<b>Consultation Response from Emma Mills</b> <b>KC Landscape</b>	
<b>Application No:</b>	2023/90024
<b>Proposed Development:</b>	Partial demolition of a Listed Building to facilitate refurbishment and extension of the George Hotel to form a 90+ room C1 hotel with associated ancillary uses (including bar, restaurant, gym, conference room) (within a Conservation Area)
<b>Location:</b>	George Hotel, St George's Square, Huddersfield, HD1 1JA
<b>Applicant/Agent:</b>	Bowman Riley
<b>Planning Officer</b>	Richard Riggs
<b>Date Responded:</b>	28 <sup>th</sup> April 2023
<b>Responding Officer:</b>	Christina Lee / Diana Brown
<b>Responding Ref:</b>	MM05

Proposed Roof Plan

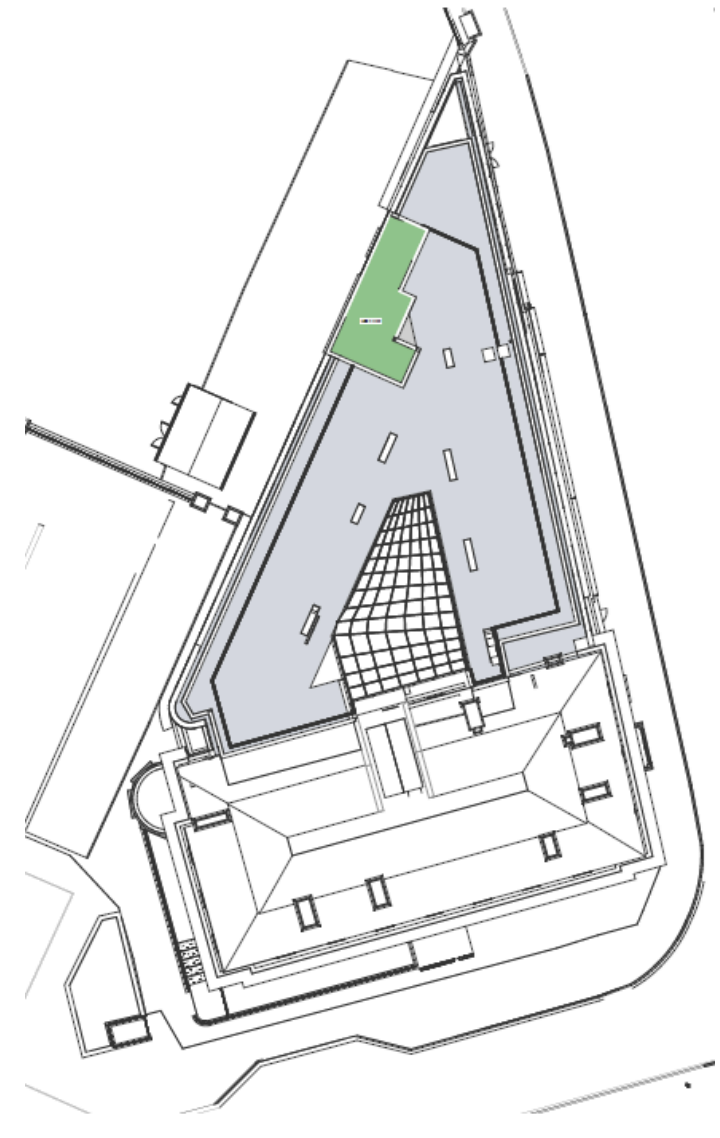
The Proposed Roof Plan drawing (8662-BOW-ZZ-ZZ-DR-A-P210) does show the presence of a proposed green roof.

We would request further details such as proposed plant species. Preference is for native species, proven to be beneficial to pollinators where possible for this location.
